Subject: **Request for Modification to Individual Section 404 and Section 401 Water Quality Certification** for the proposed construction of an extension of SR 1163 (Old Georgetown Rd) from SR 1184 (Ocean Isle Beach Rd) to NC 179 in Brunswick County, State Project 6.231023, TIP R-3432. Debit \$570.00 from WBS 35501.1.1

The purpose of this request is to modify the above referenced 404 Permit and 401 Water Quality Certification. Please see enclosed copies of the revised permit drawings and revised NCDMS acceptance letter for the above referenced project.

In order to prevent scour and undercutting the following revisions have been made:

PERMIT DRAWING SHEET 17 OF 29
REVISED 10/08/2015

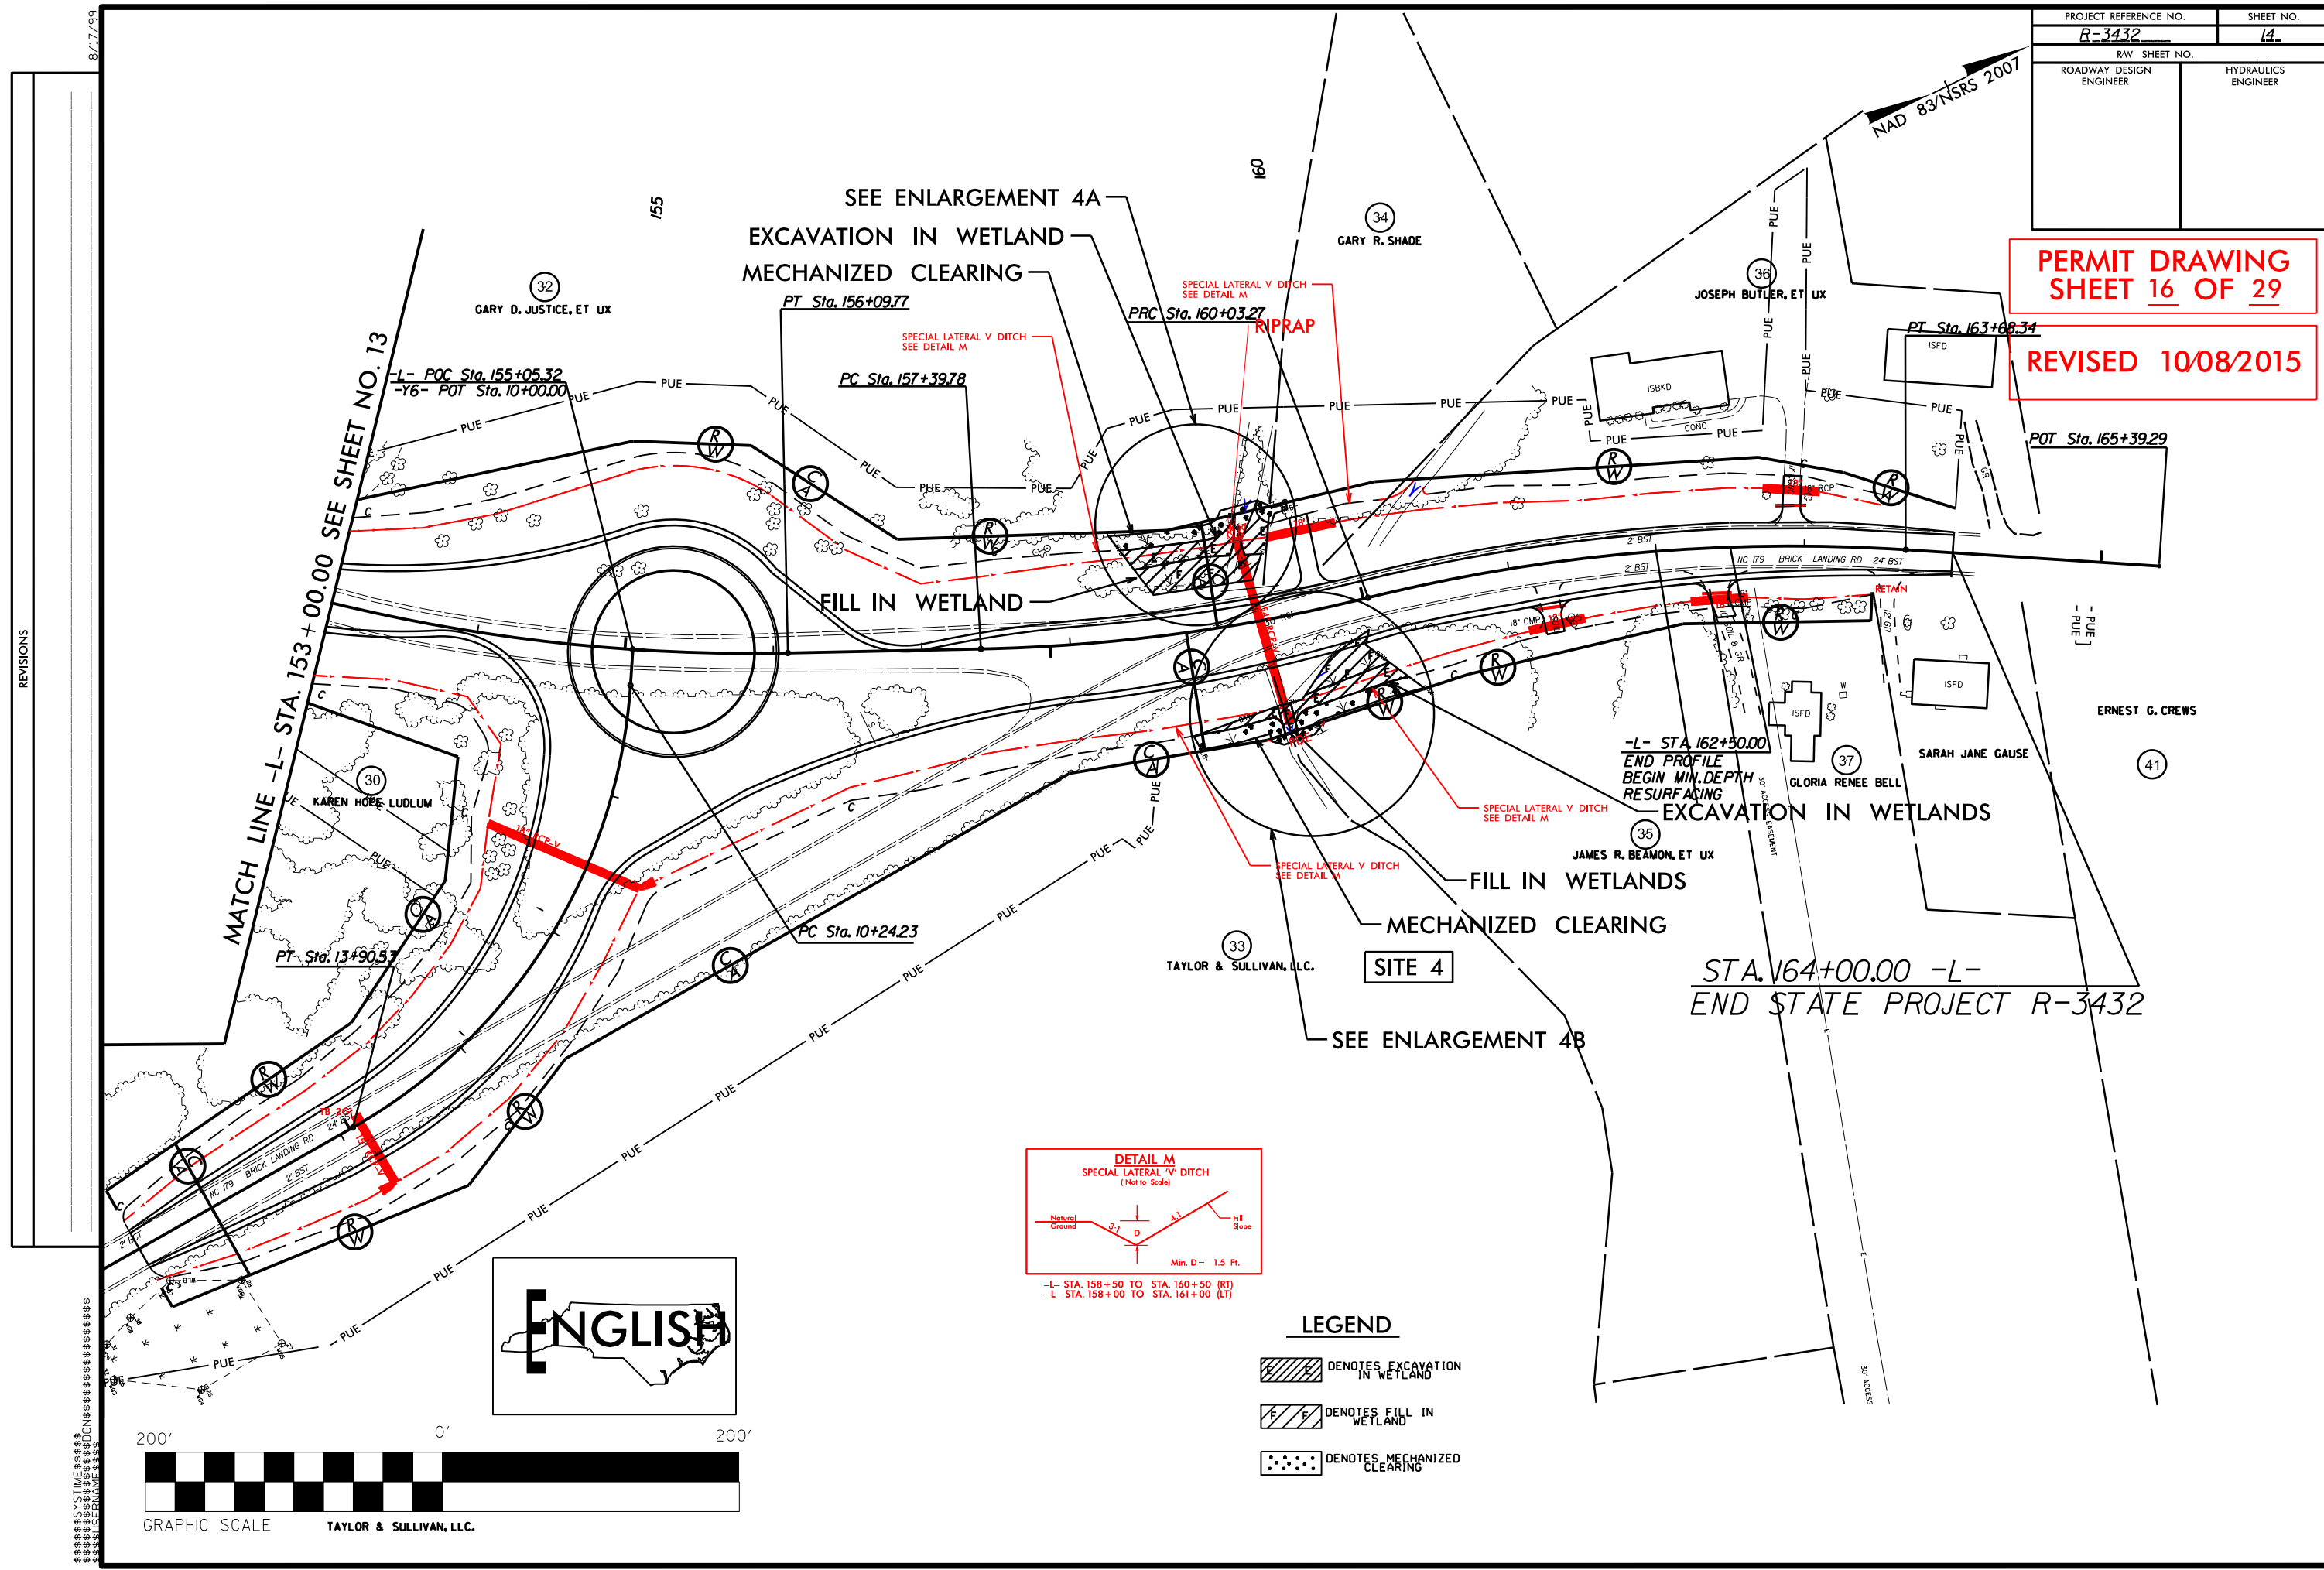
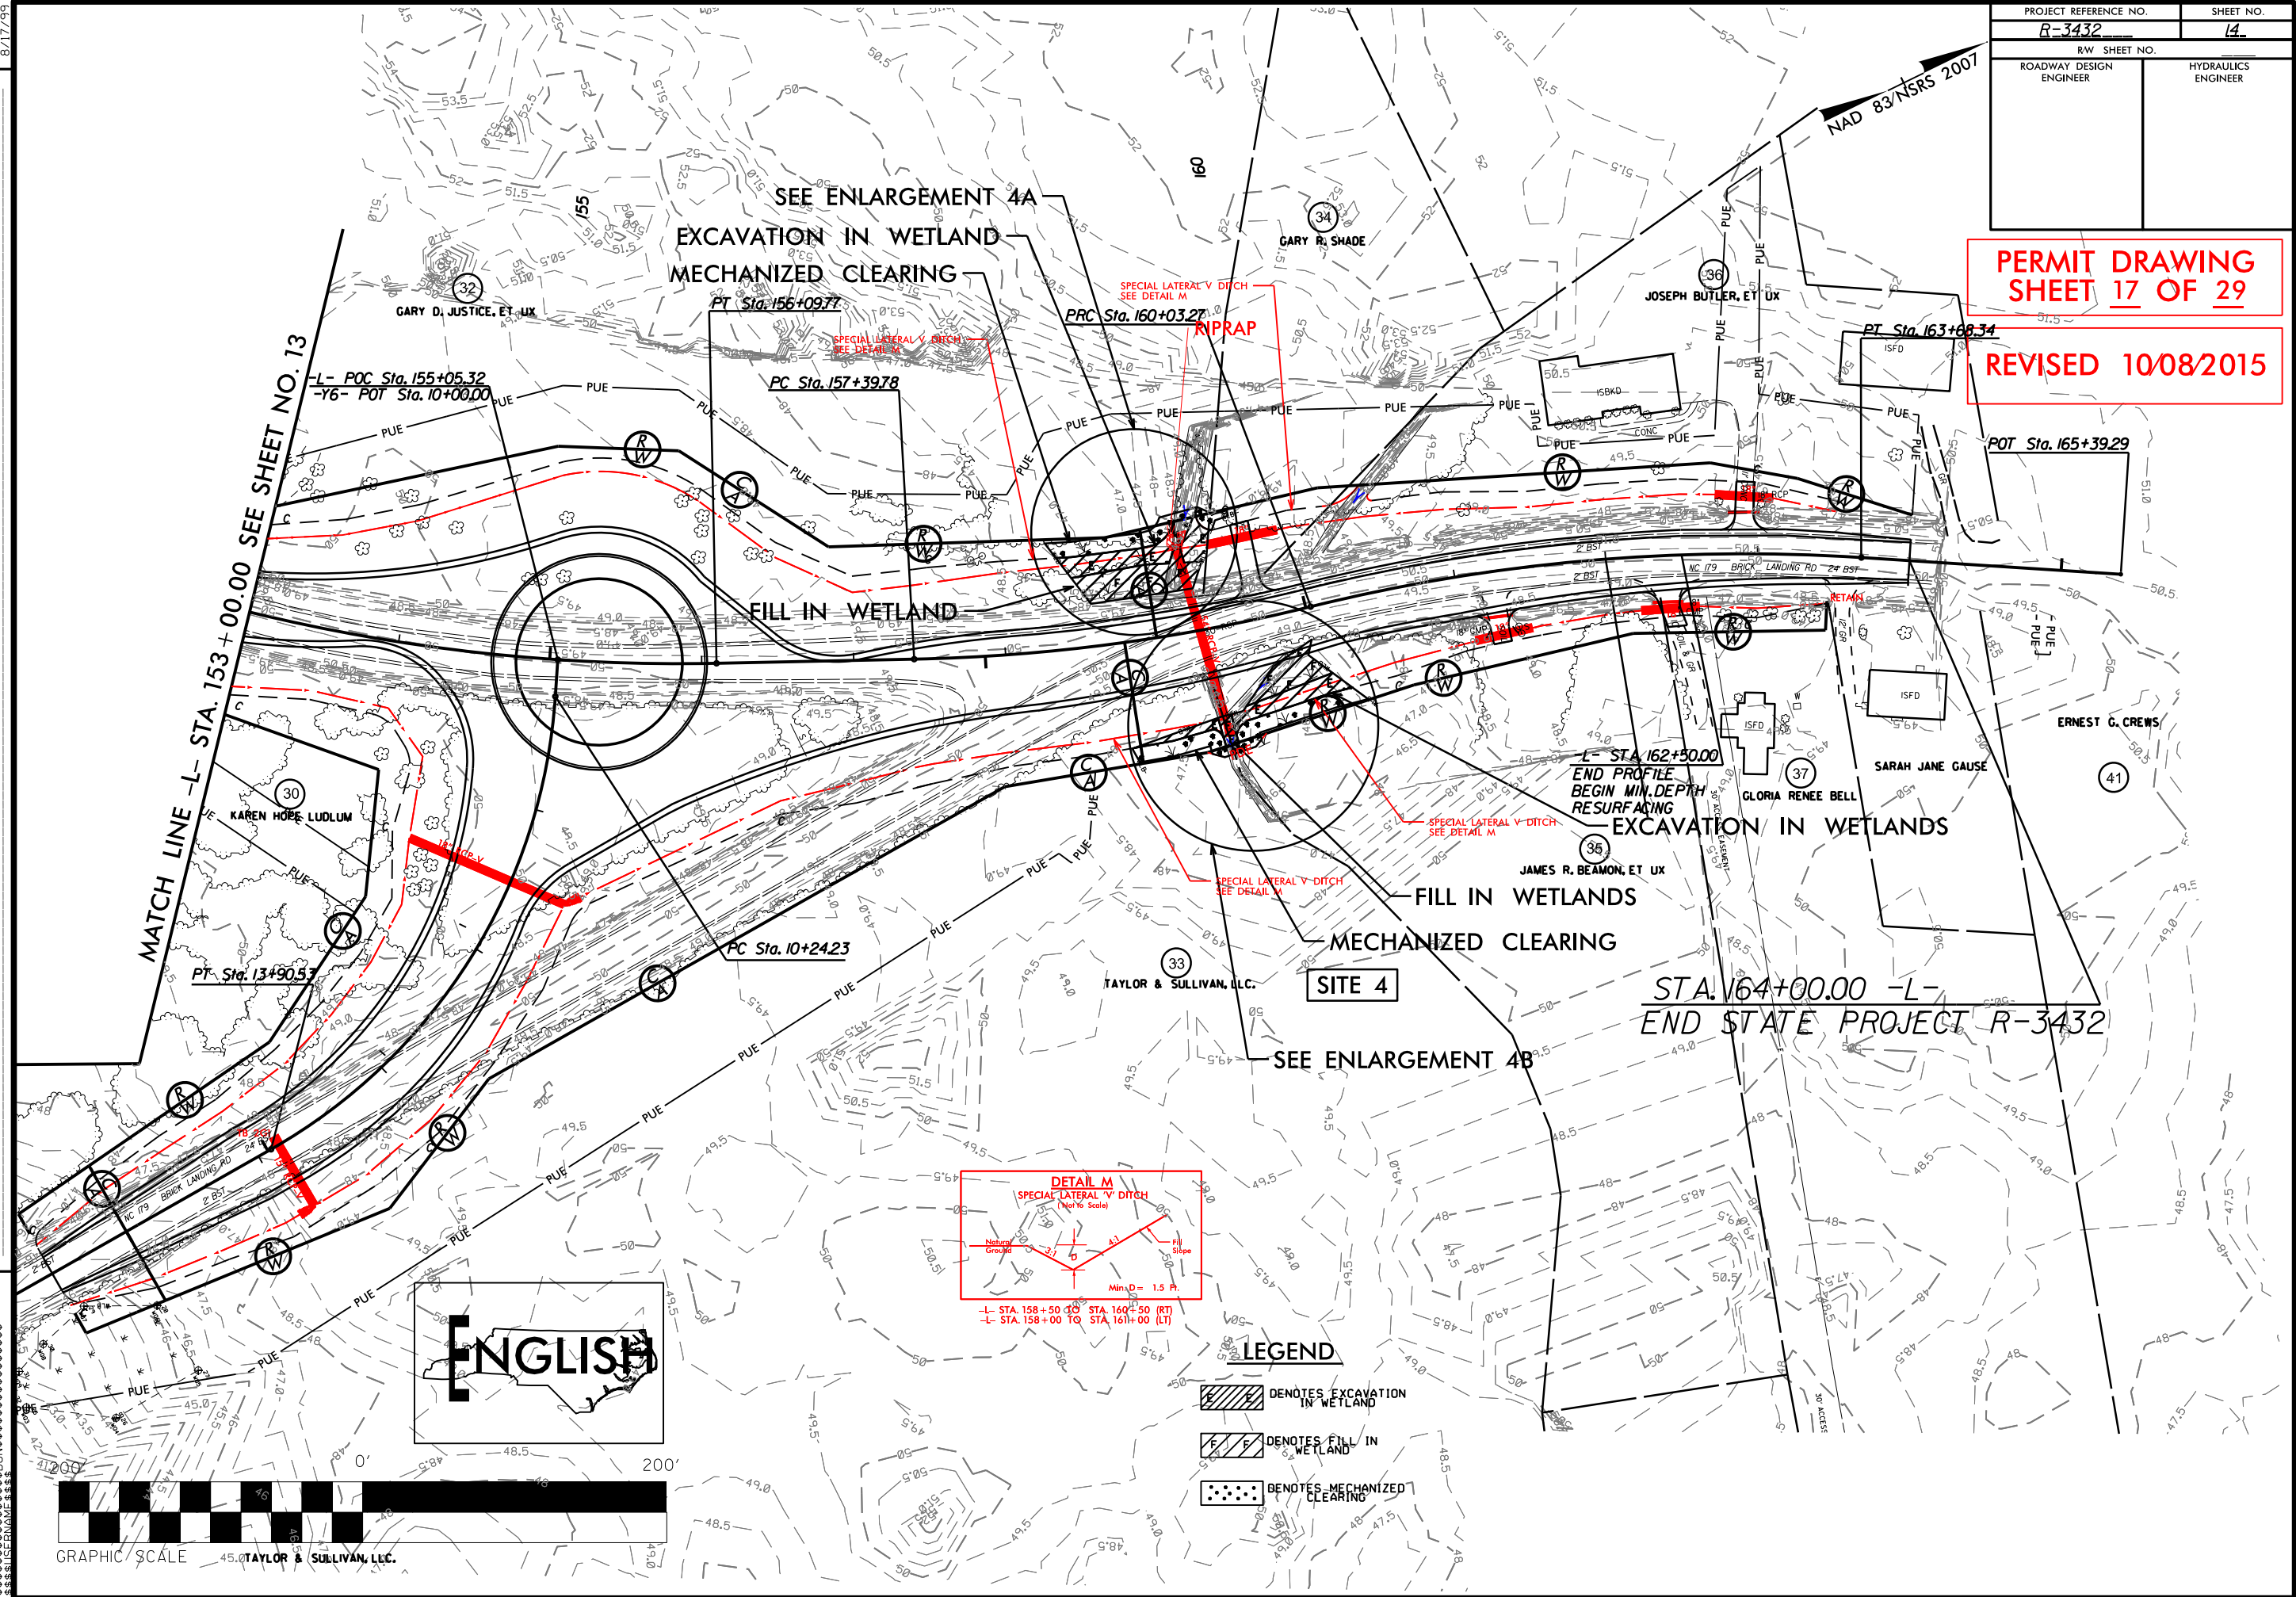
- Site 4. Additional riprap will be added at the inlet of the 54" RCP-V in prior permitted permanent impact areas.
- Site 5A. Additional riprap will be added to the bed and slopes of the relocated channel to stabilize the slopes and prevent undercutting of the log sills resulting in 97 linear ft. of permanent fill.
